From: Laura Gibbons
Sent: 23 June 2020 13:56
To: Planning.Responses [REDACTED]
Cc: Simon Davis [REDACTED]
Subject: N of Summer Lane P/35/20/DOC & P/37/20/DOC

We have the following comments regarding the revised surface water drainage details submitted for P/35/20/DOC and P/37/DOC.

Further ADC drainage comments. N.B. Strike throughs indicate comments that have been resolved.

DSM/E4761/322

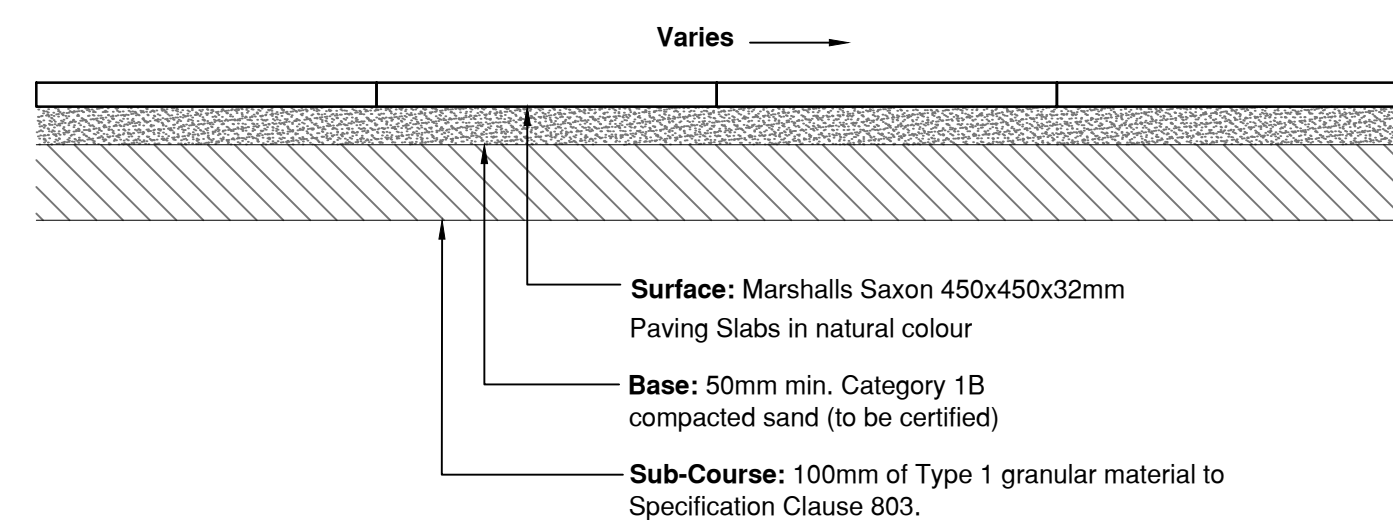
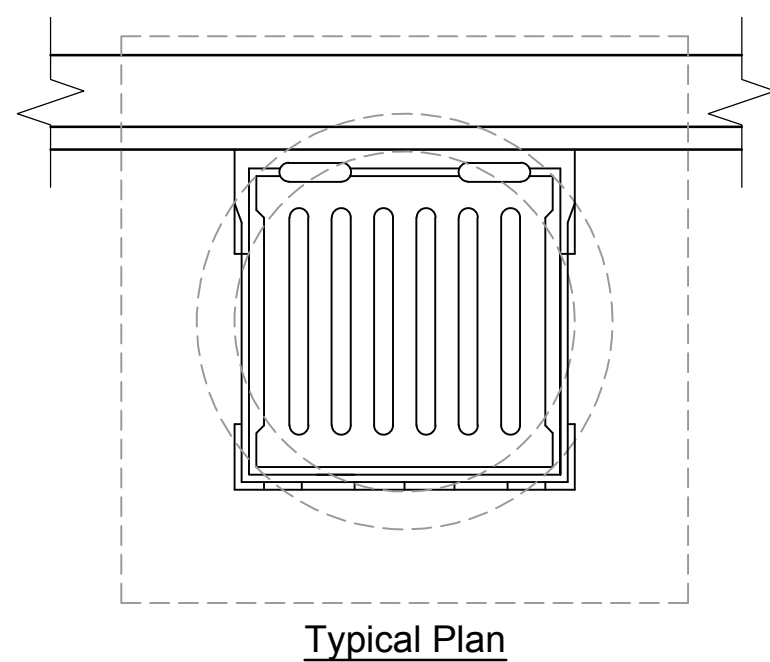
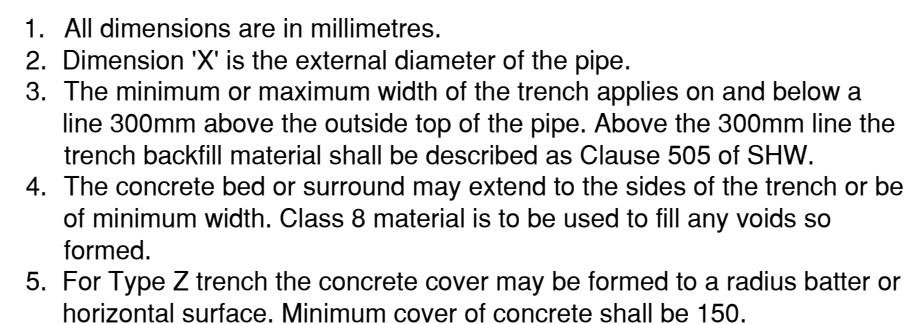
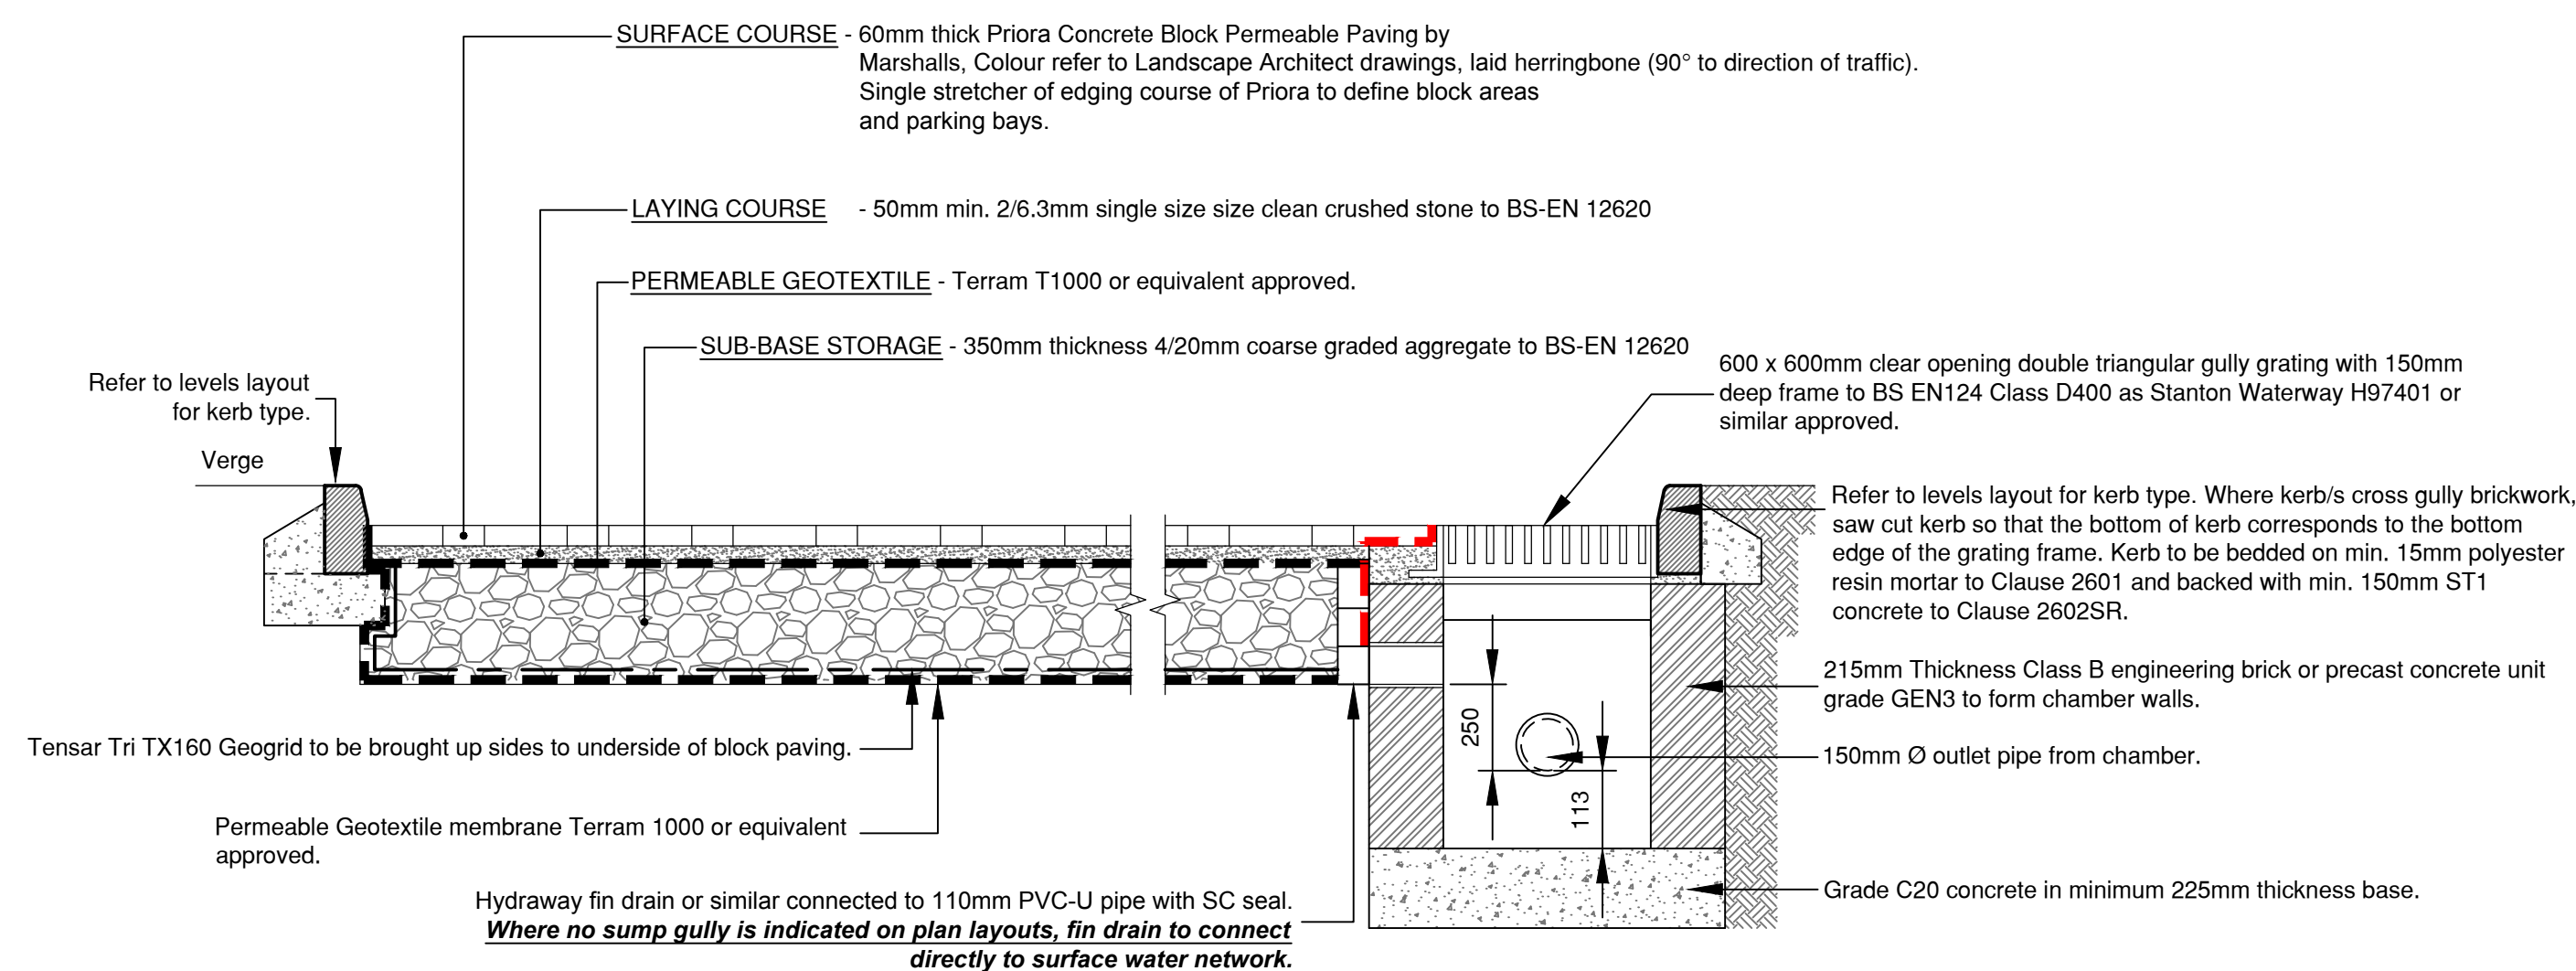
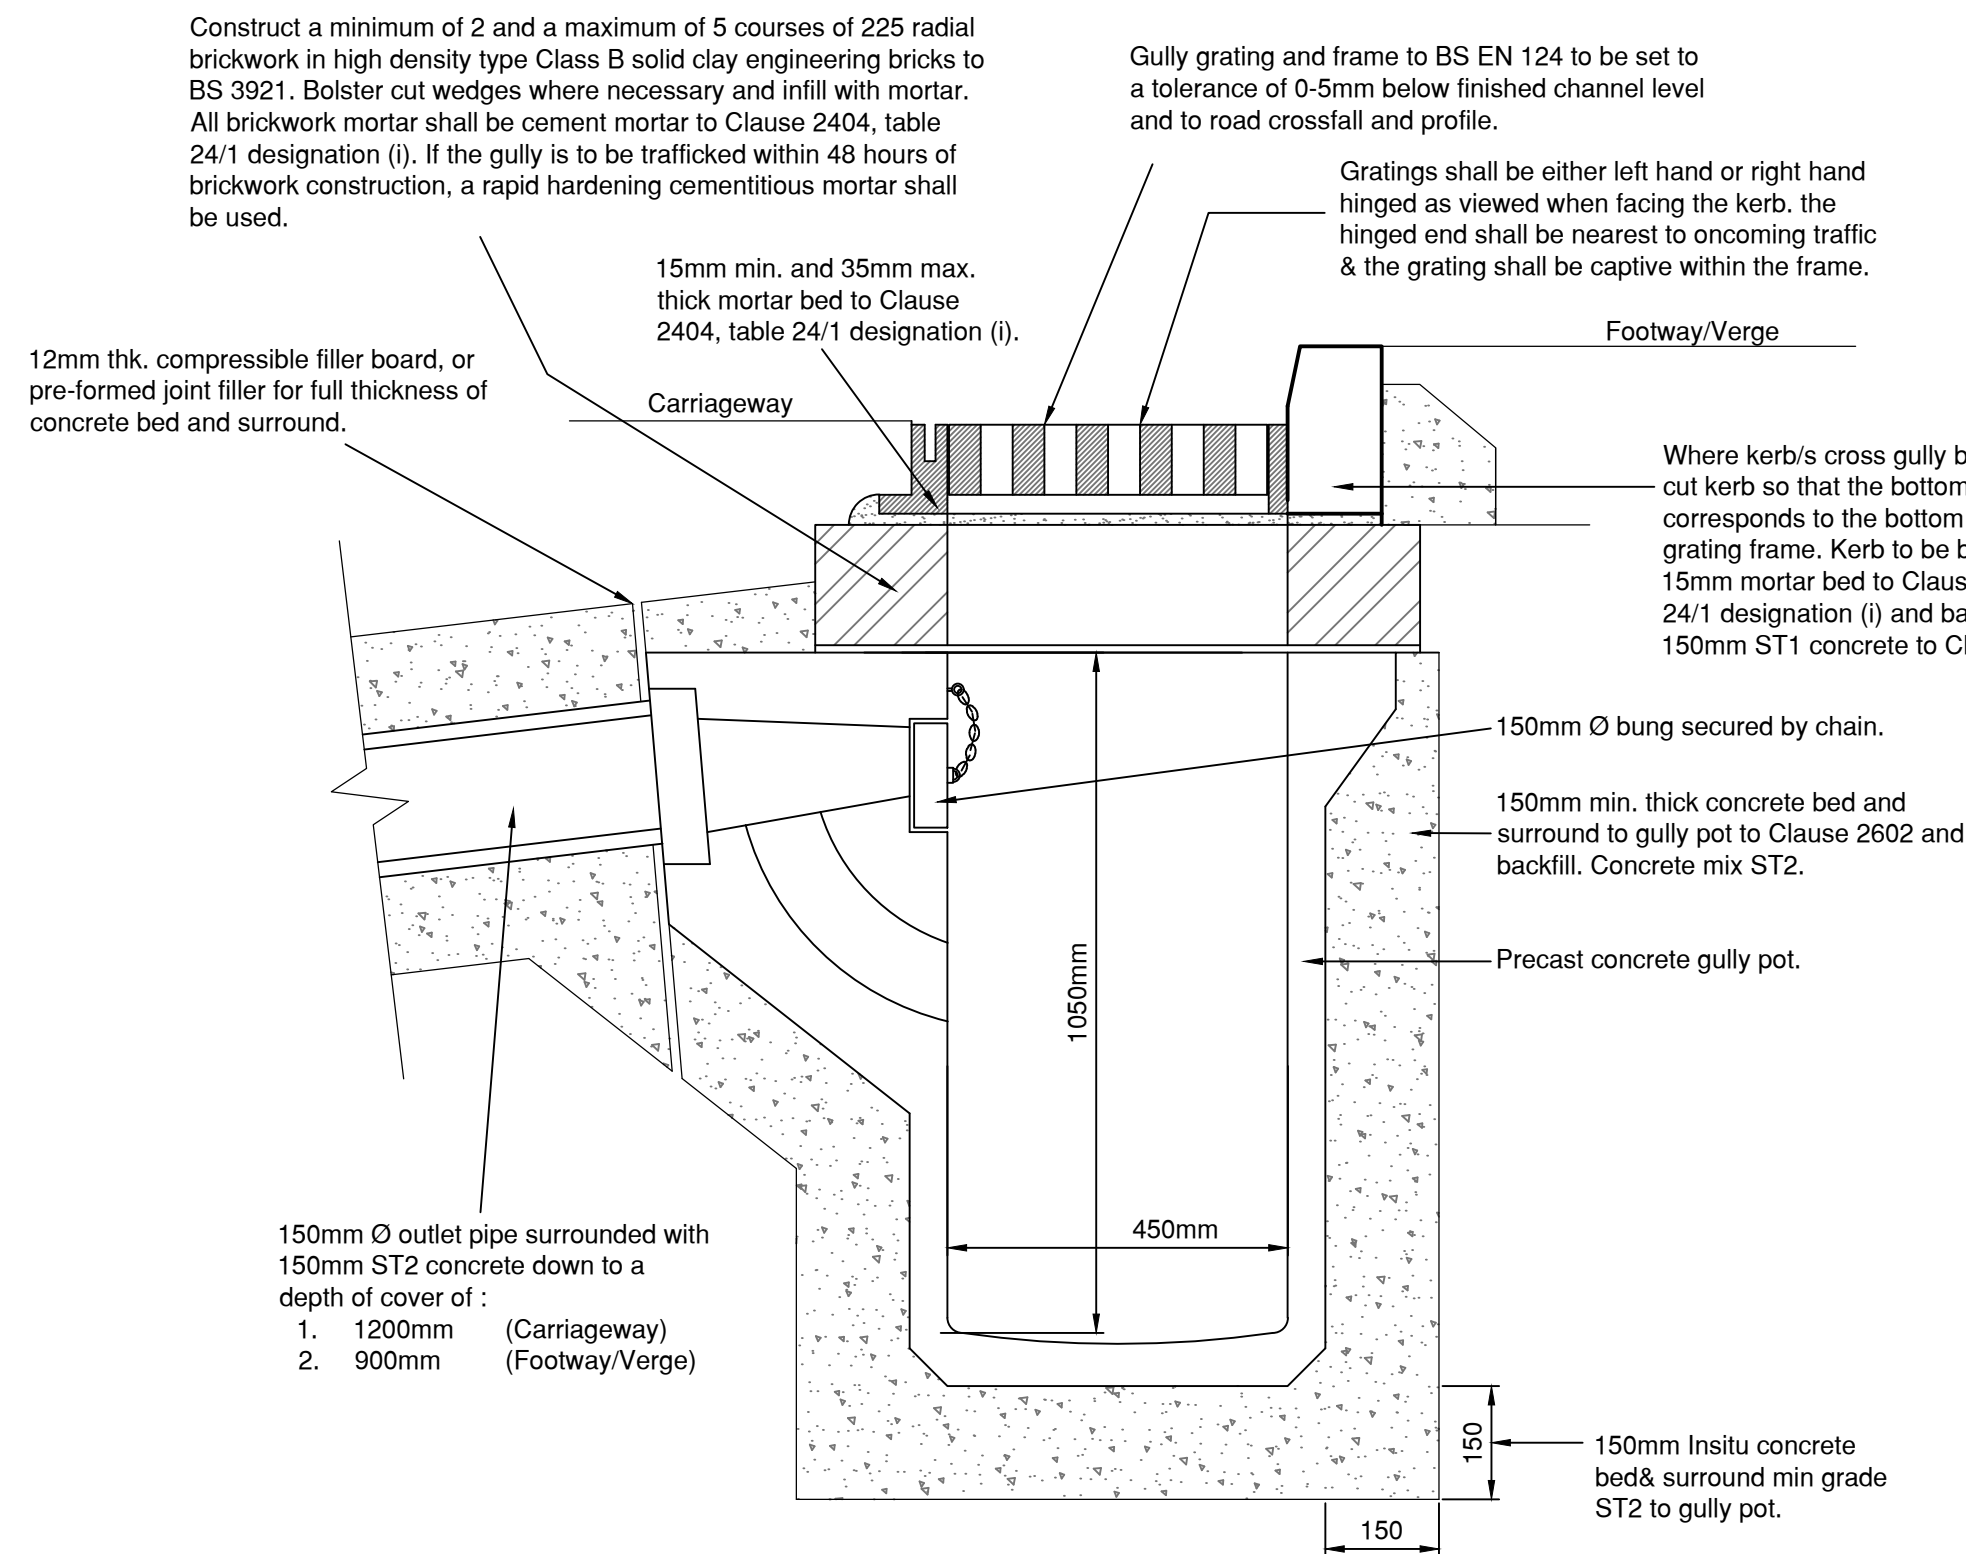
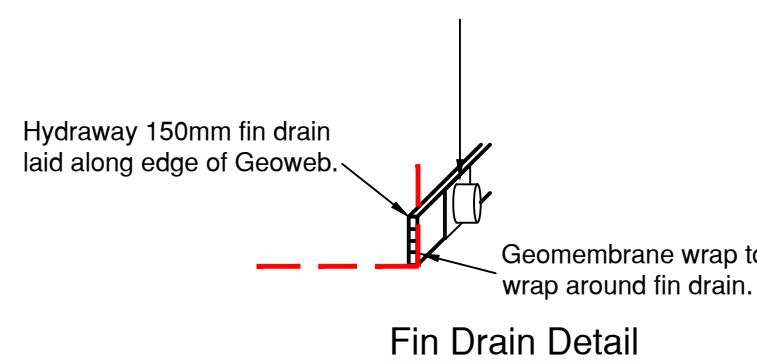
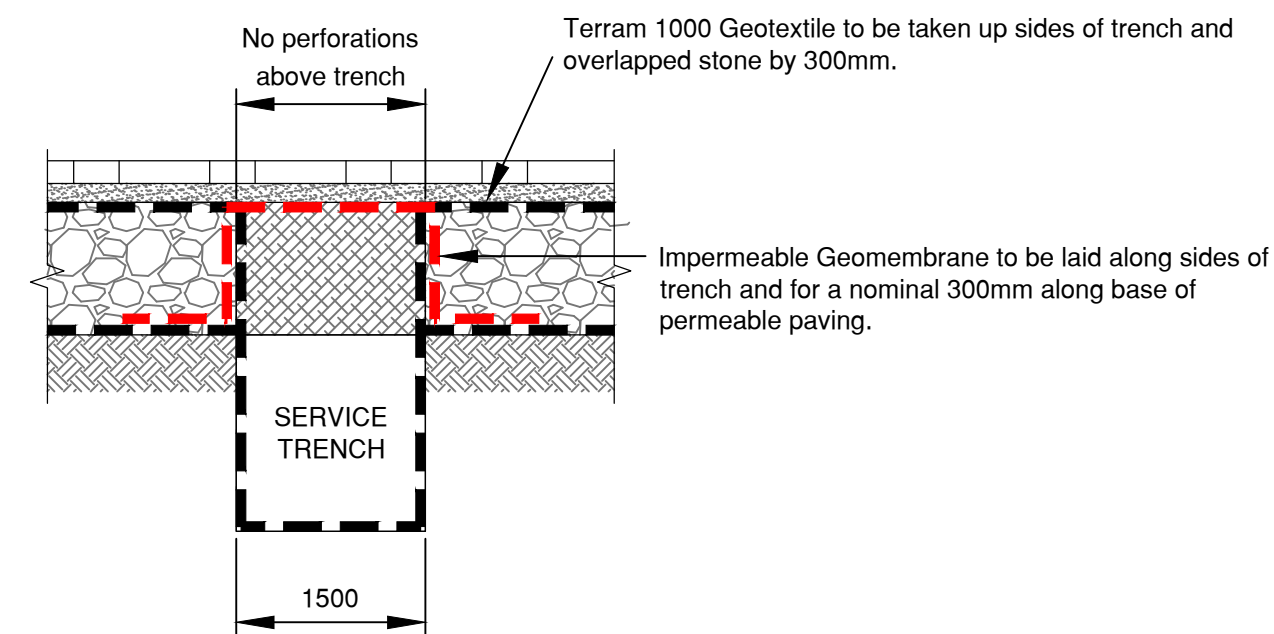
~~36. Road gully laterals – stipulate 150mm diameter pipes. -Outlet size is specified on road gully detail DSM/E4761/322 Please provide detail. Enclosed as part of information pack.~~

50. Permeable paving requires an impermeable membrane wrapping (include on construction detail) as per item 2 – this is a Type B permeable paving. Detail is provided on drawing DSM/4761/322. Note that the base of the permeable paving is higher than the recorded highest groundwater level of 4.08mAOD. *Okay, will review drawing when available. Enclosed as part of information pack.*

Drawing No. **DSM/E4761/501 A**

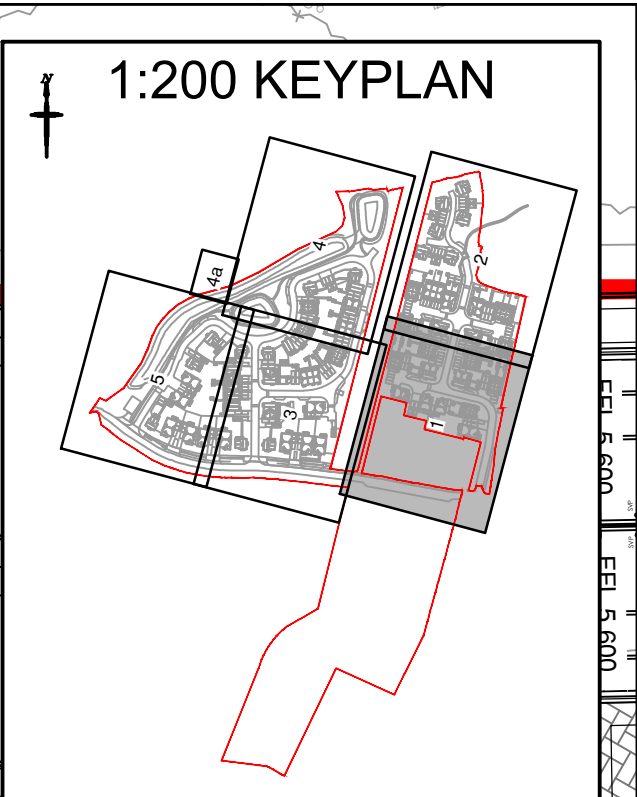
23. Show finished floor levels, permeable paving finished surface levels and base levels. This information is provided on the external levels drawings DSM/4761/551-505. The base levels for the permeable paving are a constant relative depth to the finished levels as the make ups are constant,

as it's a type b permeable paving system *Please supply these plans.* Enclosed as part of information pack.
